Western Museum of Mining & Industry (WMMI)

WMMI parking and traffic management plans (3.1)

WMMI Campus Layout - Summary Table 3.1 — Variance for Business Event Center

WMMI parking lots – Lower Campus

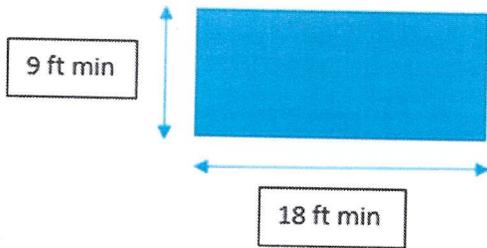
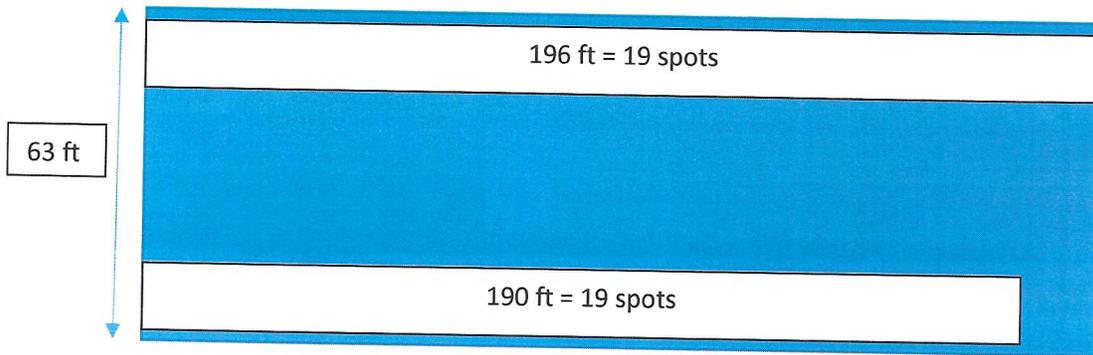
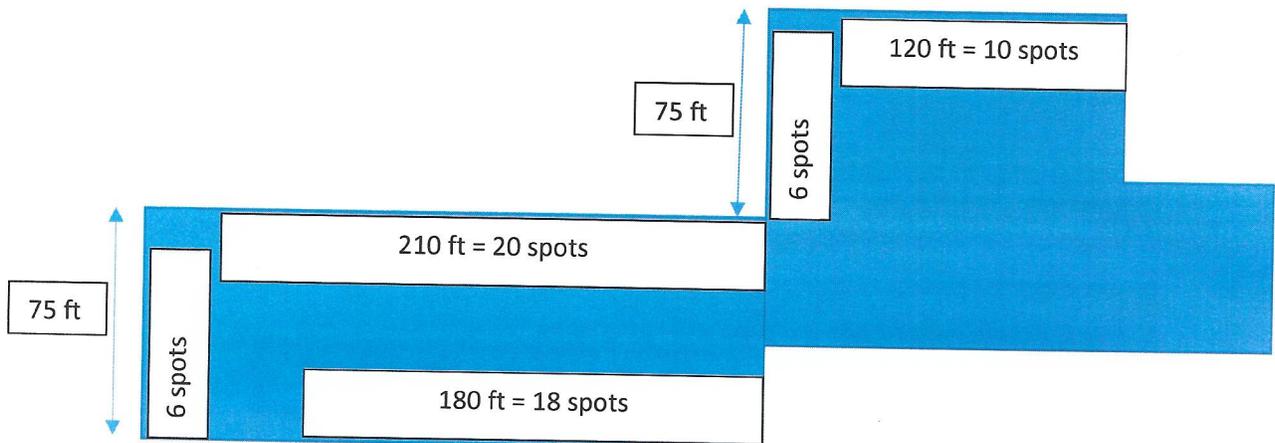
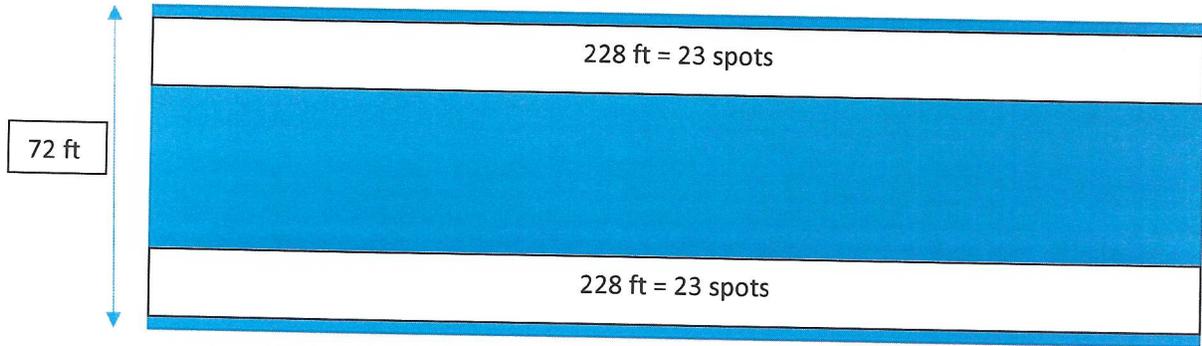
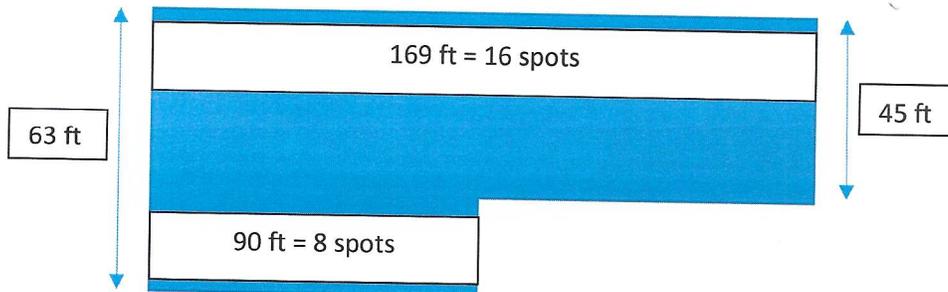
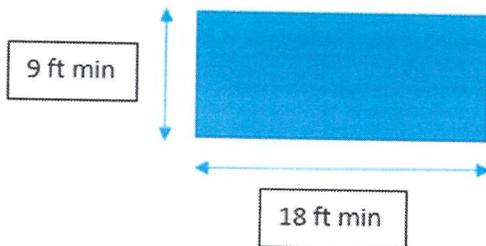
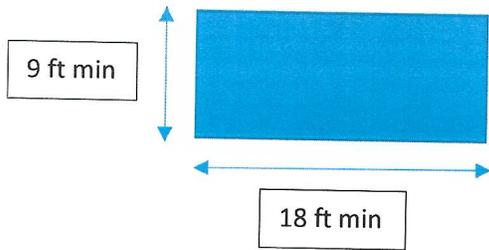
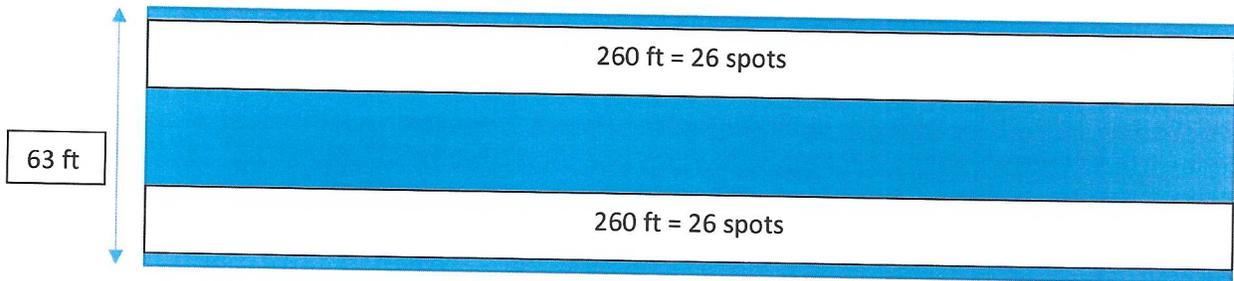
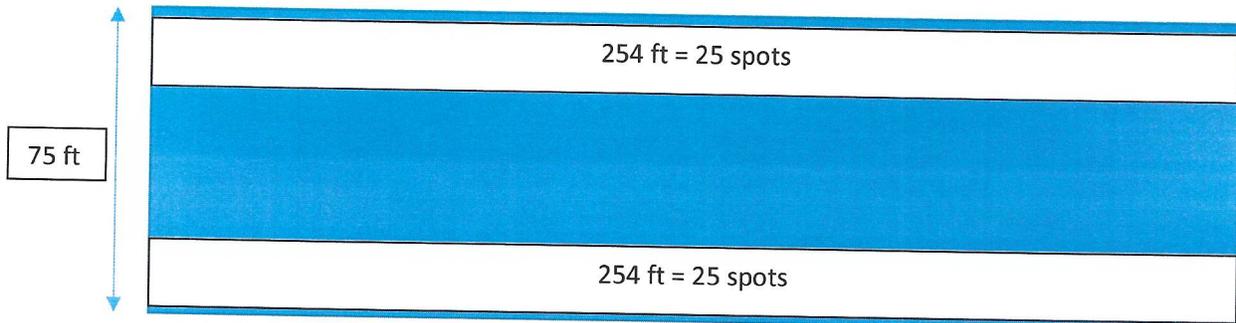
please provide typical dimensions for the individual spaces as well as not they will be denoted on site (applies to all parking areas). You may choose to do so with a since drawing and explanation.
